**SOUTH DERBYSHIRE DISTRICT COUNCIL’S ANSWERS
TO THE EXAMING AUTHORITY’S SECOND WRITTEN QUESTIONS**

ANSWERS FOR DEADLINE 5

Oaklands Farm Solar Farm NSIP

PINS Reference: EN010122

Figure 15.1: Agricultural Land Classification Results

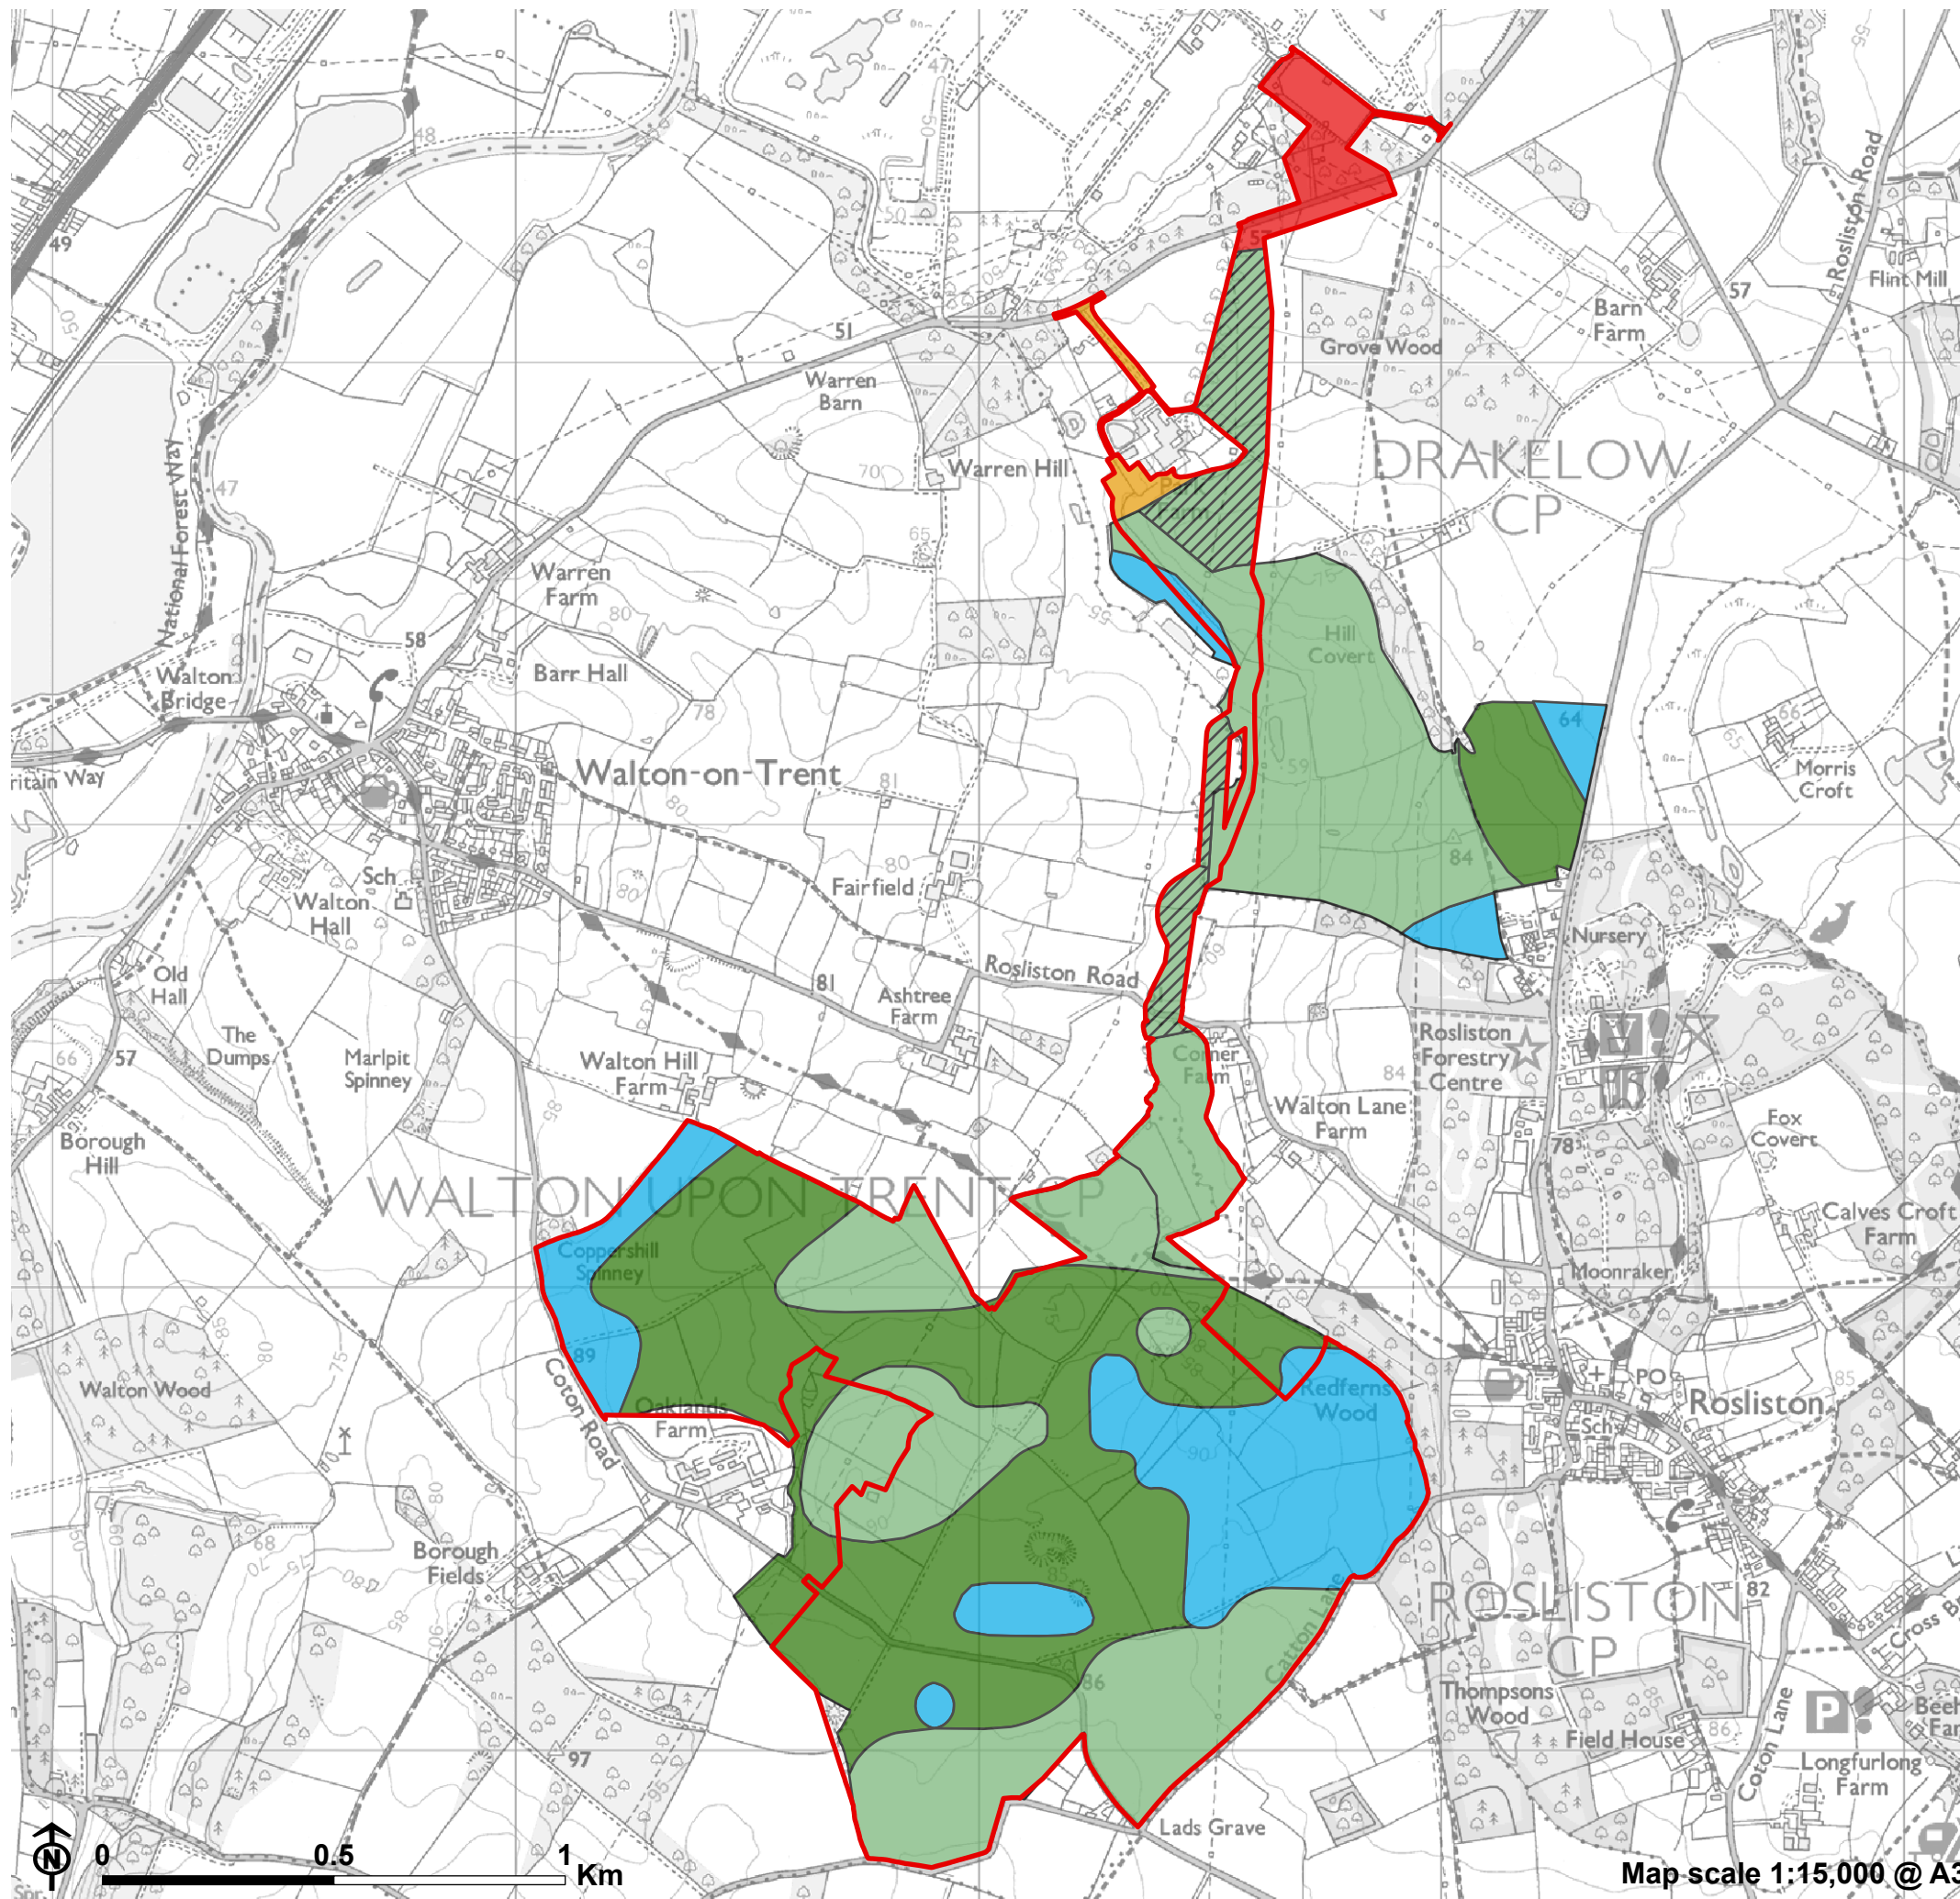
6.1	<p><u>Agricultural Land Classification (ALC)</u></p> <p>NE [AS-022, REP1-037] raise various concerns regarding ALC, including:</p> <ul style="list-style-type: none"> • where BMV is not expected then a semi detailed survey (1 auger per 2 ha plus representative pits) will suffice; • in areas that BMV is expected then a full ALC (1 auger per ha plus representative pits) must be undertaken; • it does not concur with the assumption that land quality is mostly 3b within the cable route; 	<p>b) SDDC are content that the surveyors work was to an acceptable standard and by undertaken by appropriate surveyors.</p> <p>d) SDDC have not had any recent dialogue with the Applicant regarding ALC. SDDC would generally concur with NE’s comments. SDDC would also add that soil scientists (surveyors) should be BSSS standard, and that ALC survey must inform the Soil Management Plan.</p>

Ref:	ExA’s Question	SDDC Answer:
	<ul style="list-style-type: none"> • an ALC survey should be undertaken on the cable route; • in the absence of a detailed survey for most of the cable corridor it is impossible to provide an accurate baseline and demonstrate the likely potential impacts; • the survey requires an experienced ALC surveyor to make the correct professional judgements; • detail should be provided of the professional credentials and experience required of soil scientists (surveyors) experience carrying out ALC; and • the ALC survey will inform the Soil Management Plan. <p>SDDC [REP1-029] consider that the Applicant’s ALC and surveys meet the minimum criteria of MAFF 1988, but say that the soil survey work was not supervised/ observed.</p> <p>NE [AS-022] provide detailed comments on the Applicant’s ALC undertaken to date and say [REP1-037] that it will provide more detailed comments for Deadlines 2 and 3. The ExA notes that these are yet to be submitted.</p> <p>The Applicant [REP1-023, REP1-025, REP3-032] considers the approach and methodology used within the ALC and surveys to be robust and appropriate. It says that is engaging with NE on a SoCG. It states that it is undertaking further survey work to confirm the ALC on the cable route and will provide an update on the results of the survey at Deadline 4.</p> <ul style="list-style-type: none"> a) Please could the Applicant clarify the supervision provided for all ALC and surveys, including for the soil survey work on site, setting out the relevant professional credentials and experience of the surveyors/ scientists? b) Please could NE and SDDC comment on the supervision provided by the Applicant at Deadline 5? 	<p>e) SDDC are of the opinion that without a survey it cannot be accepted that the land quality at the location of the cable route is mostly 3b.</p>

Ref:	ExA’s Question	SDDC Answer:
	<p>c) Please could the Applicant provide a draft copy of the SoCG with NE at Deadline 4, and set out the ALC matters yet to be agreed with NE and the next steps to be taken to address them?</p> <p>d) Please could NE and SDDC set out any remaining ALC concerns at Deadlines 4 and 5, summarise any related discussions with the Applicant, and suggest how their issues might be resolved?</p> <p>e) Please could NE and SDDC provide their comments on the results of the Applicant’s ALC on the cable route at Deadline 5?</p>
